**KIRKLEES METROPOLITAN COUNCIL  
INVESTMENT & REGENERATION SERVICE**

**DELEGATED DECISION FOR DISCHARGE OF CONDITION -  
NOTIFICATION OF TELECOMMUNICATIONS DEVELOPMENT**

**Reference no. 2023/N /91250/E**

**Description Prior notification for proposed 15m  
5G telecoms installation: H3G  
street pole and additional  
equipment cabinets**

Title: **265 PROPOSED SITE ELEVATION**

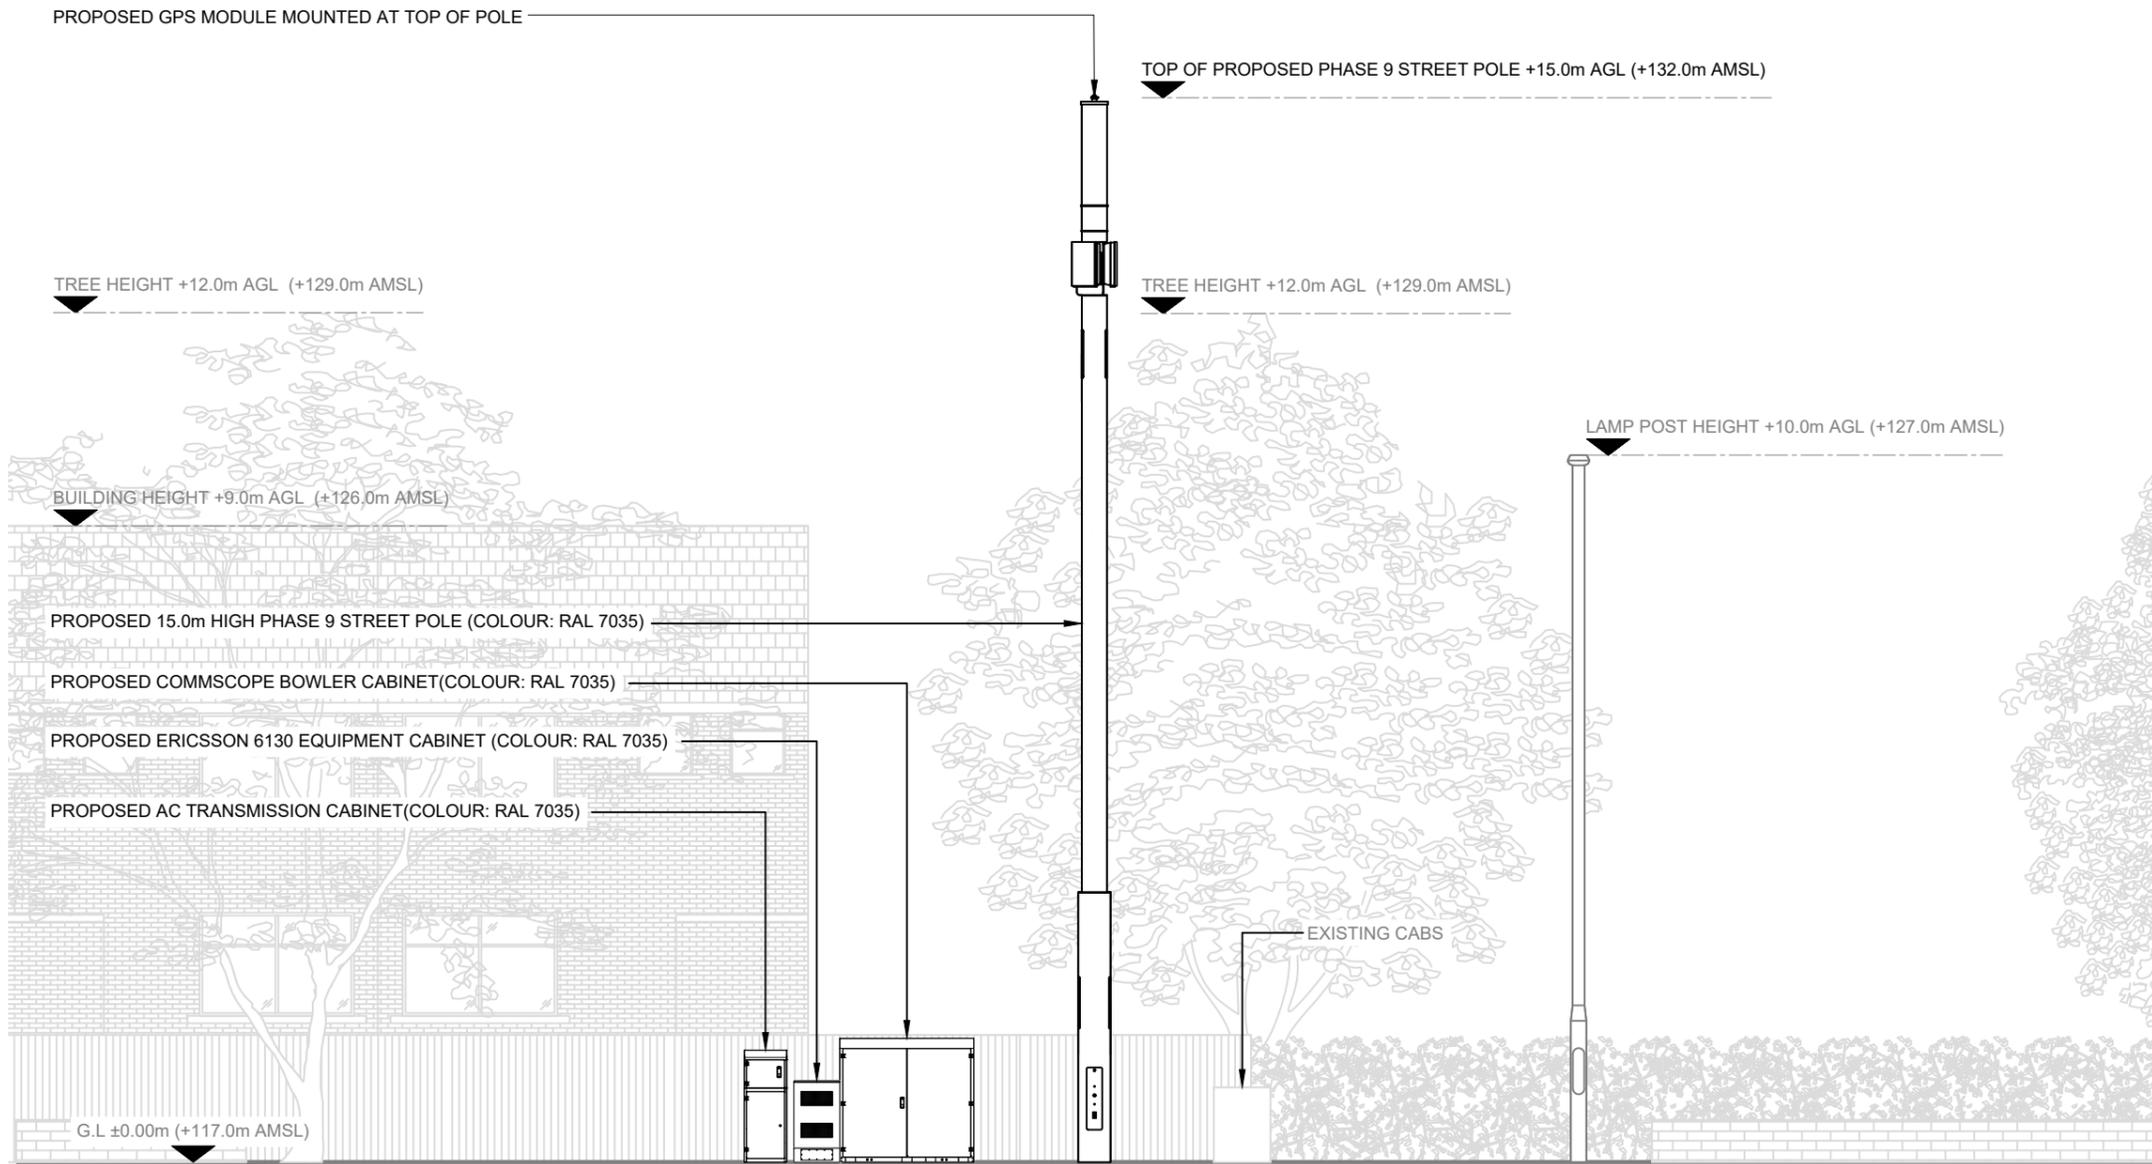
The new mast would be located on an existing pavement adjacent to the highway. There is one lamppost on the grass verge on Church Lane, and one on the pavement on Bradford Road. However, these are both of a significantly lower height (10m) and are slimmer lightweight features compared to the proposed mast. The neighbouring residential dwellings are of a significantly lower height (approximately 9m) compared to the proposed 15m mast. The mature vegetation to the rear would also be significantly lower in height than the proposed mast, as demonstrated on the submitted plans. Any benefit of the vegetation would be seasonal, as these are deciduous trees. The mast would be significantly higher than all other features in the area. It is considered that it would therefore dominate the existing built development and be out of character with the local area.

Officers' concerns are intensified by the open nature of the site with no screening to reduce the prominence of the mast. Coupled with the height of the mast (15m), this would result in the mast being visible for some distance when travelling along Owl Lane and Leeds Road.

It is noted that the mast has been amended to a more slimline design compared to the previous refused submission (2023/90056). However, officers consider that this would not wholly overcome concerns relating to the size of the mast or its siting, as set out in the reason for refusal of the previous application.

*the streetscene.*” In this instance it is considered the mast is significantly overt and dominant on the streetscene, with the harm to visual amenity outweighing the need for infrastructure.

The proposed mast, by reason of its siting, size, and appearance would be a visually

intrusive and incongruous feature in the streetscape appearing wholly out of scale with the surrounding residential properties and failing to respect the character of the area. The proposed development would therefore be contrary to Policy LP24 of the Kirklees Local Plan and Chapters 10 & 12 of the National Planning policy Framework. In addition the applicant has not demonstrated that any site/building closer to or within the nearby industrial area cannot be discounted in so far as the proposed location is the only reasonable location to achieve the aims of chapter 10 of the National Planning Policy Framework.
